**“ATTENTION: DIRECTOR, INFRASTRUCTURE PROJECTS”**  
**DEPARTMENT OF PLANNING AND INFRASTRUCTURE**  
**Resident Submission: NWRL EIS2 Application Number: SSI-5414**

Application Name:  
“Graham Bull - Resident Submission NWRL EIS 2 – Cherrybrook Traffic Management”

**3. Application Number: SSI-5414**

Figure 6.12 Cherrybrook Station - Indicative vehicle and pedestrian movements

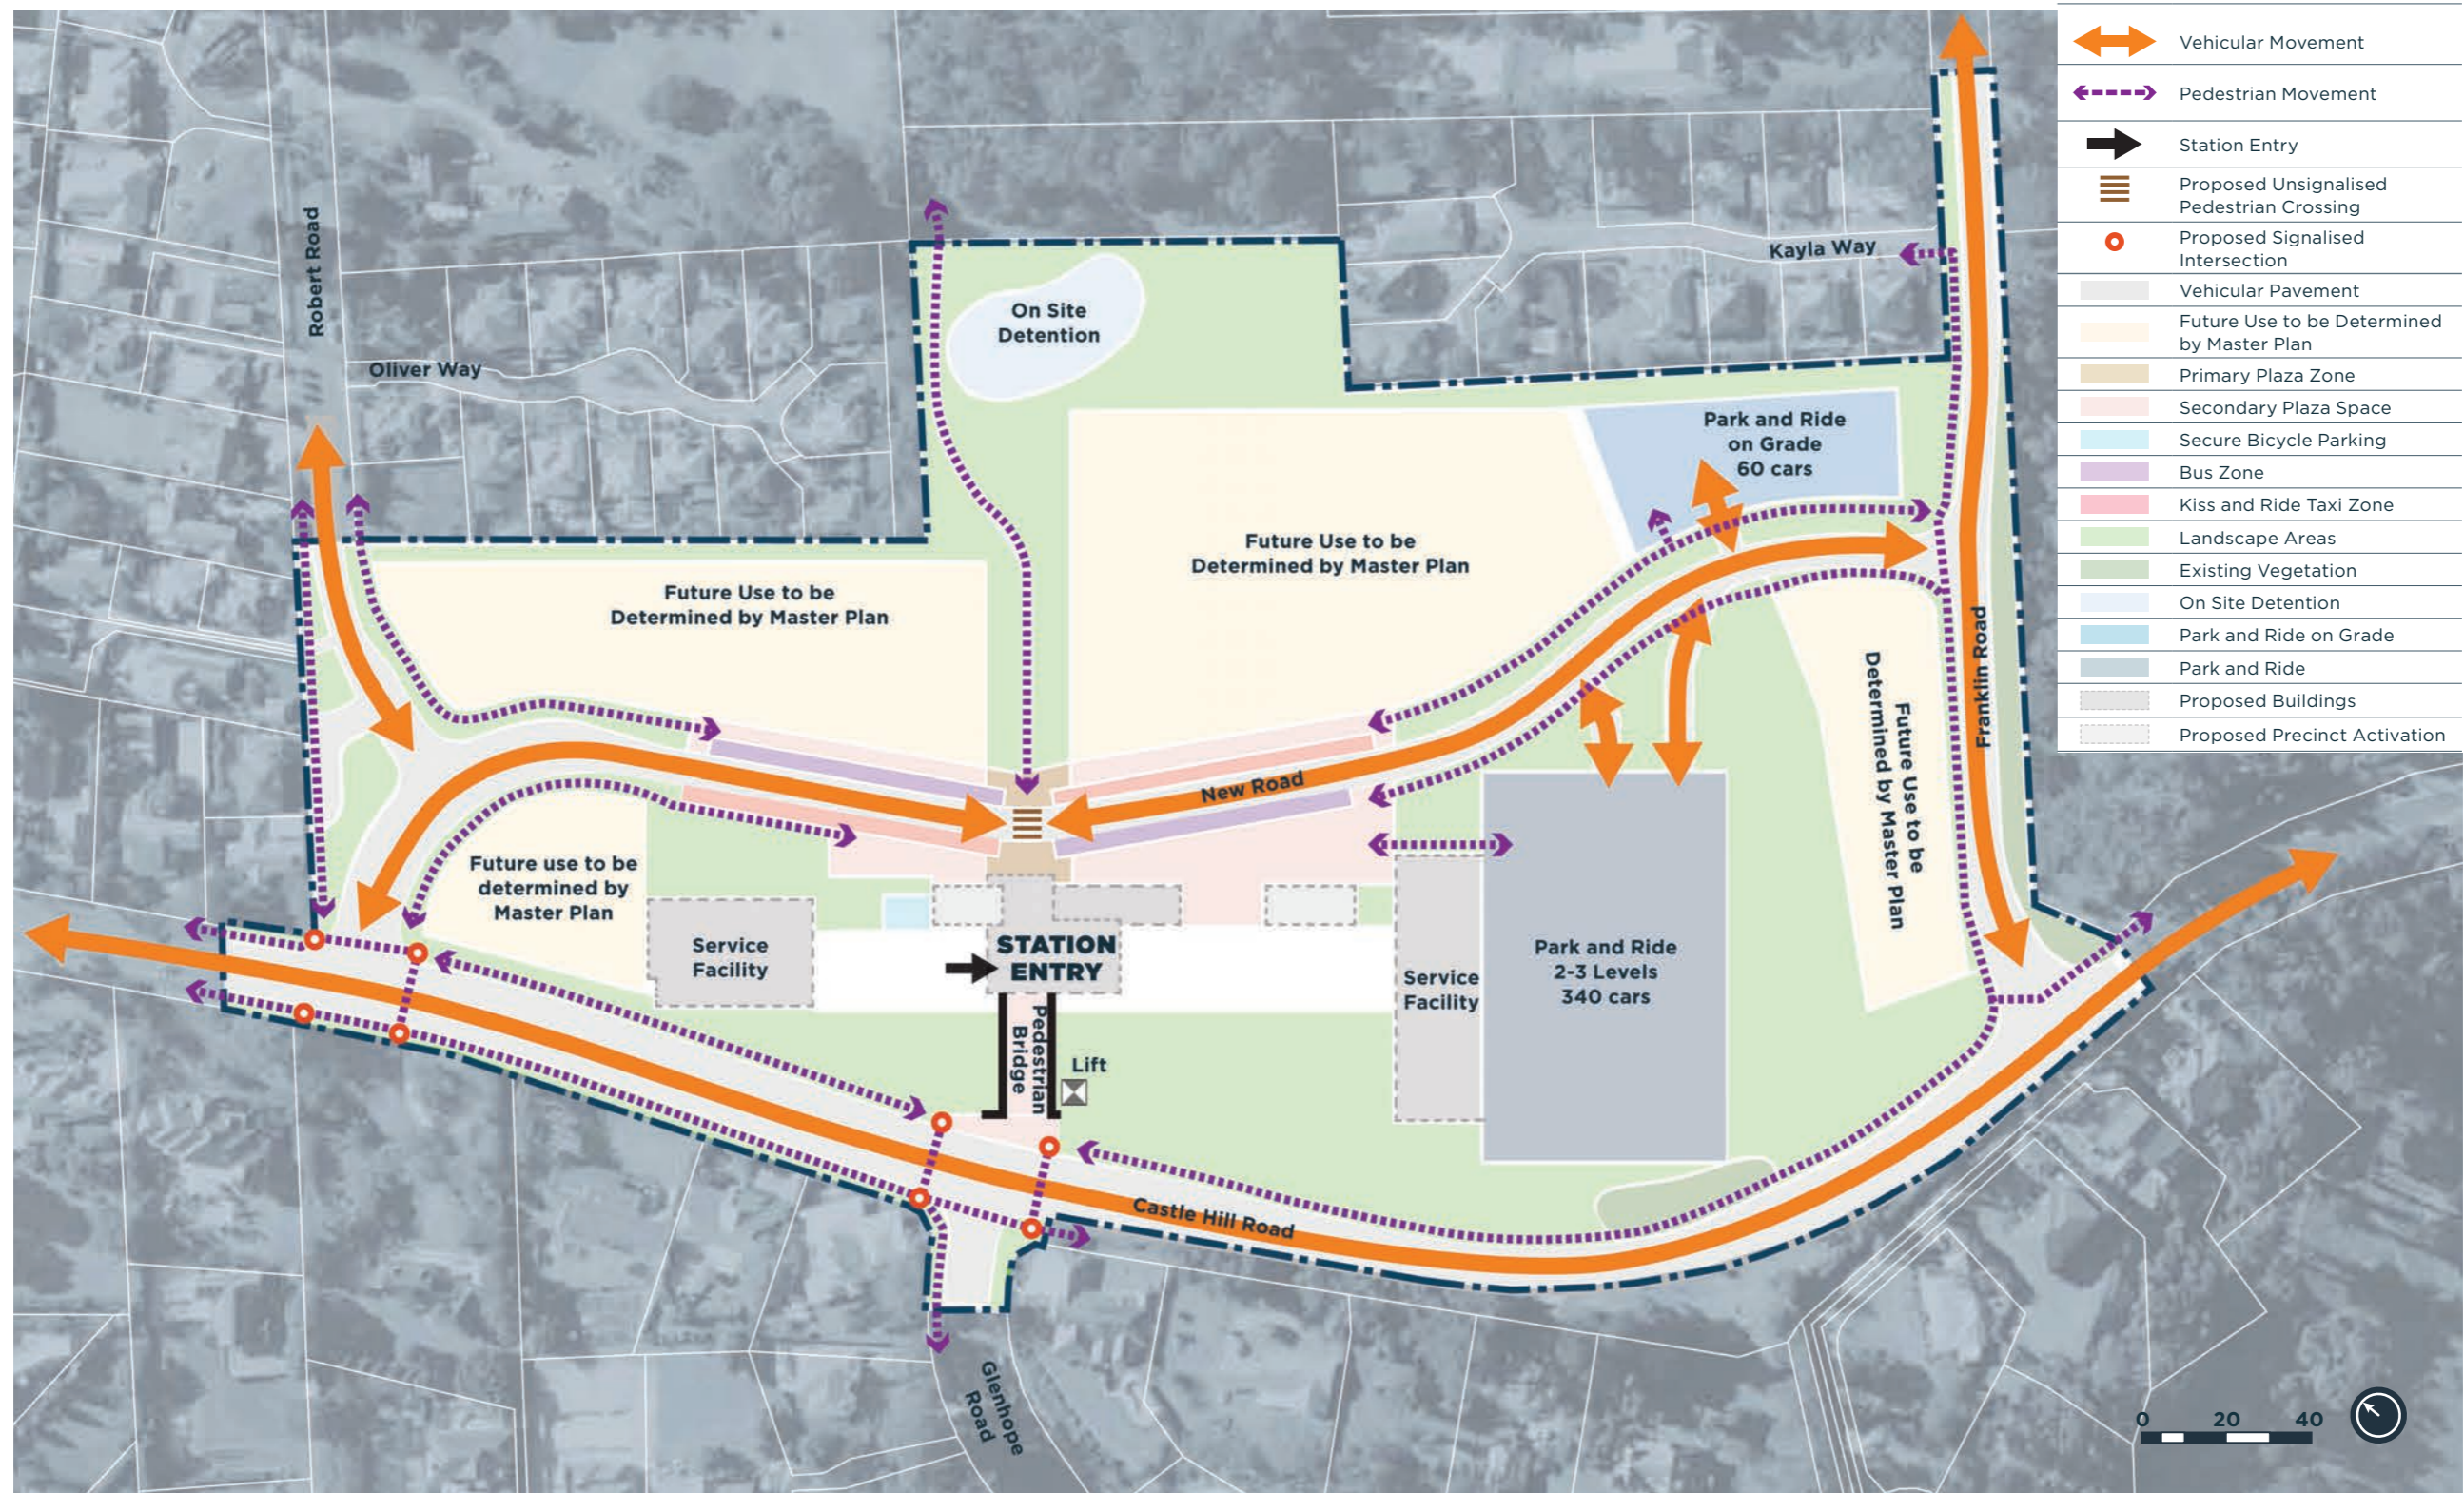
Both Robert Road and Franklin Road are typical suburban streets servicing the needs of residents. They are certainly unsuitable in their current form to become primary feeder roads to Cherrybrook Station as proposed in NWRL EIS 2.

**a) Robert Road would become an unworkable traffic bottleneck**

Robert Road currently accommodates immediate residential traffic from the following roads that feed into it.

- Arundel Way – Private road of 31 homes
- Camelot – Private road of 5 homes
- Louise Way – Private road of 17 homes
- Oliver Way – Private road of 15 homes
- Dalkeith Road – The only access for all homes in a network of dead end streets flowing into it and on to Robert Road.

Proposed “no parking” in Robert Road is unacceptable. Arundel Way has no guest and service vehicle parking on site. Other Private Roads would be similarly affected.

Dalkeith Road and the dead end roads that flow into it would become a bottleneck for residents entering and exiting their homes should Robert Road become the primary suburban feeder road to Cherrybrook Station.

**b) Franklin Road, containing Tangara School for Girls and Inala for adults with disabilities, in addition to becoming another traffic bottleneck would pose a major pedestrian safety hazard for Tangara students and Inala residents.**

- Tangara has a student population of 600 girls from Kindergarten to Year 12. Franklin Road is already congested with traffic during drop-off and pick-up times.
- Inala accommodates approximately 40 adults with disabilities who live in group homes on the corner of Castle Hill Road and Franklin Road. Residents with varying disabilities walk while some drive each week day to Inala's "Dulkara Centre for Life Skills and The Arts " located a short distance away on Franklin Road. It should be noted that the The Dulkara centre is located directly opposite Tangara School and requires disabled attendees to cross the road from the Inala residential section to attend the training centre.
- Pedestrian safety for Tangara students and Inala residents would be seriously threatened under the proposed use of Franklin Road as part of the primary traffic feed into Cherrybrook Station.

Significant yet sensible changes to the NWRL EIS 2 proposal need to be made to achieve this. The aim would be to create a major (and only) car and bus station access hub to Cherrybrook Station on the Castle Hill side of the station.

- a) Move the location of the station back between Robert/Franklin Roads to provide substantial space for the car and bus hub.
- b) Permanently close the Castle Hill Road ends of both Robert Road and Franklin Roads. Therefore the only entry into Robert Road will be from John Road. The only entry into Franklin Road will be from John Road and Neale Avenue.
- c) The proposed connecting road linking Robert and Franklin Roads at the Station is unnecessary under this submission.
- d) Maintain the current 642 Bus Route (and others) between County Drive/ John Road/ Neale Avenue/ Edward Bennett Drive.
